CITY OF PORTLAND

RE: 43 Fallbrook Street – 161-E-009 – R-5 residential zone – application #04-1741

I am in receipt of your application to change the use of your property from a single family to a two family with a two story addition. Your permit has been denied because you are not meeting the requirements of the City's Land Use Ordinance.

SKETCH OF
 VASSALLO PROPERTY
 PORTLAND, MAINE
 LEWIS & WASINA, INC.
 12/10/2004
 Project No. 24037
 SCALE: 1"=20'

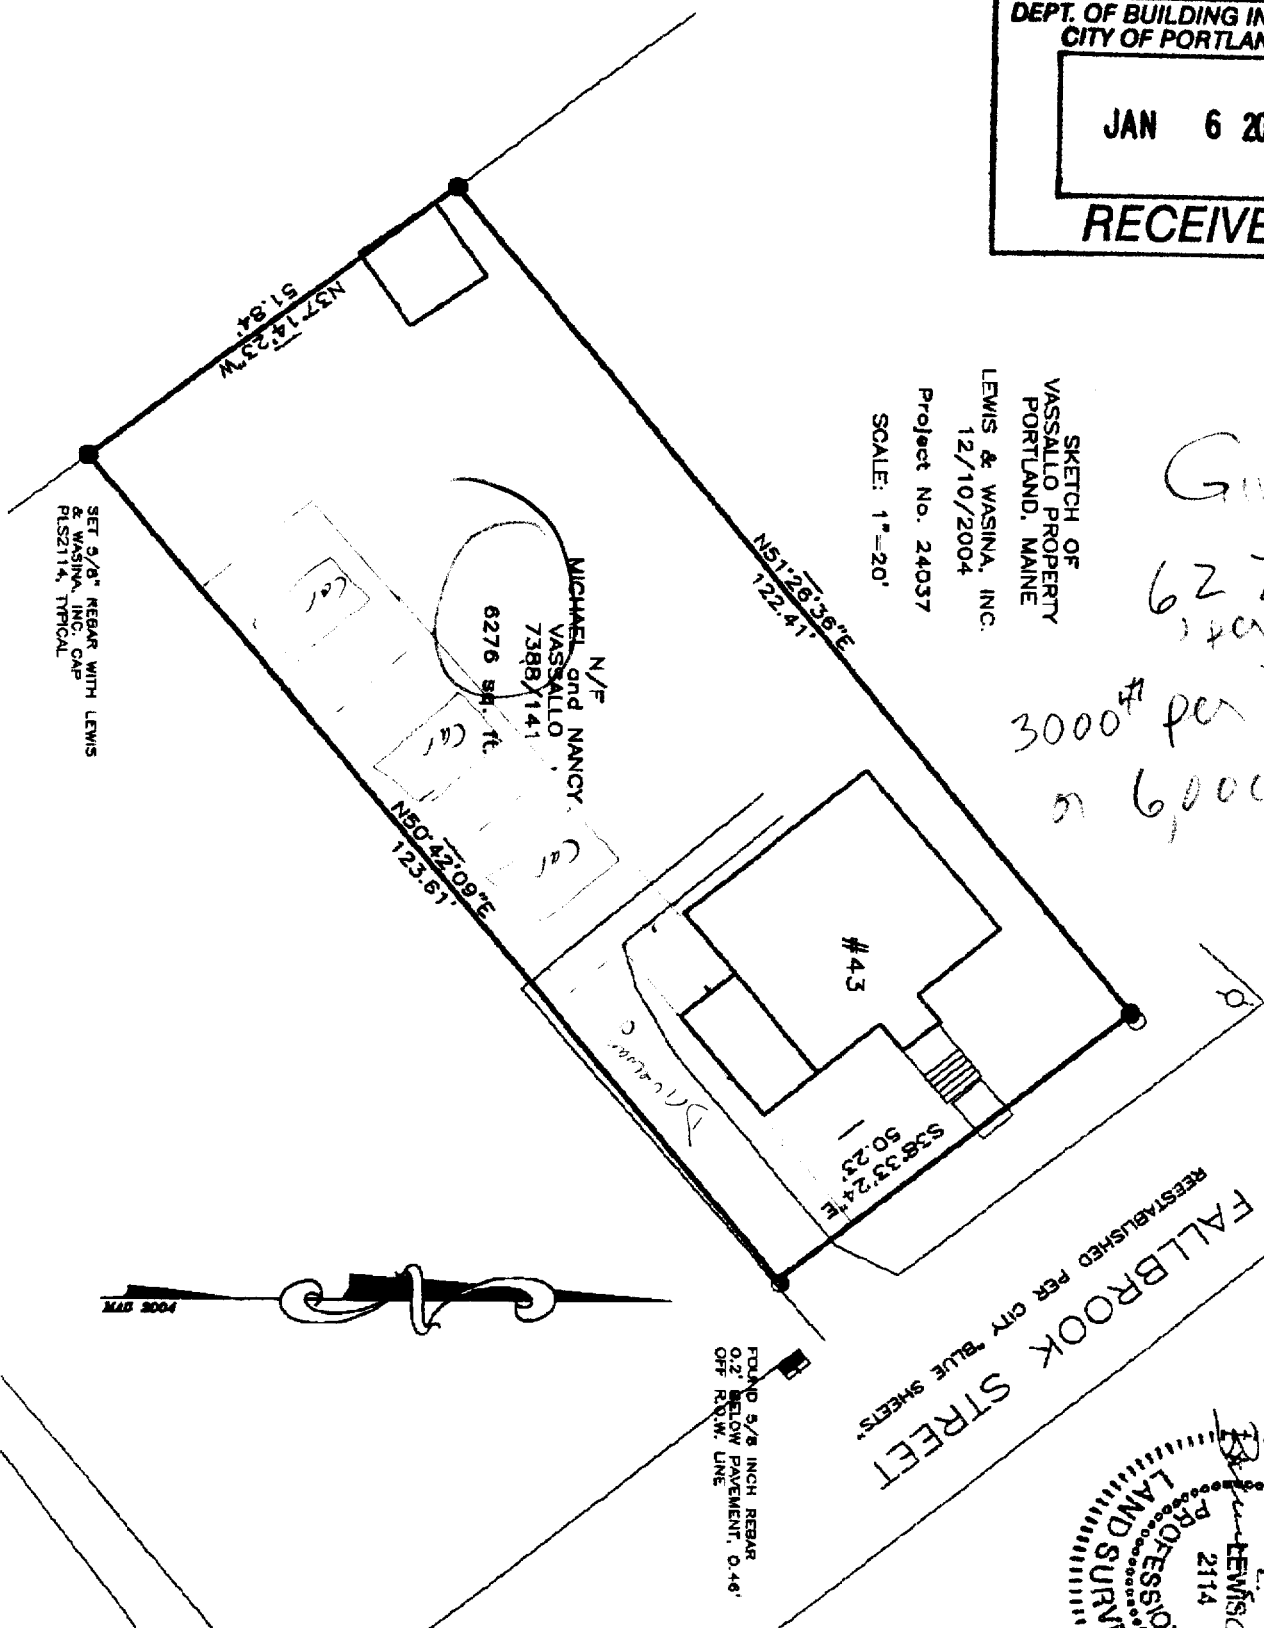
Section 14-120(b) requires a minimum of 3,000 square feet of land area per dwelling unit. Your property is shown to be 5,900 square feet of land area instead of the required 6,000 square feet minimum.

Your plot plan does not denote the number of off-street parking spaces that you are providing for this property. You need to show specifically the number of off-street parking spaces that you will be providing. Please note that a parking size is required to be a minimum of 9' x 19' when you show them on a plan.

Your plans show a shed on the rear of your property. **Our** building record files do not show an approved permit for the rear shed. Currently this 8' x 10' shed is not meeting the side and rear setback requirements under section 14-120(d) of the zoning ordinance. Your plans show less than the 5' minimum requirements allowed for a detached structure less than 100 square feet. It will be necessary at this time to legalize this shed with a permit application. It will also be necessary to bring the shed into compliance with the currently zoning ordinance.

Attached you will find a sketch of the Vassallo property showing the results of the boundary survey we performed in October. We determined the area of the parcel to be 6275 square feet and corners were marked as shown.
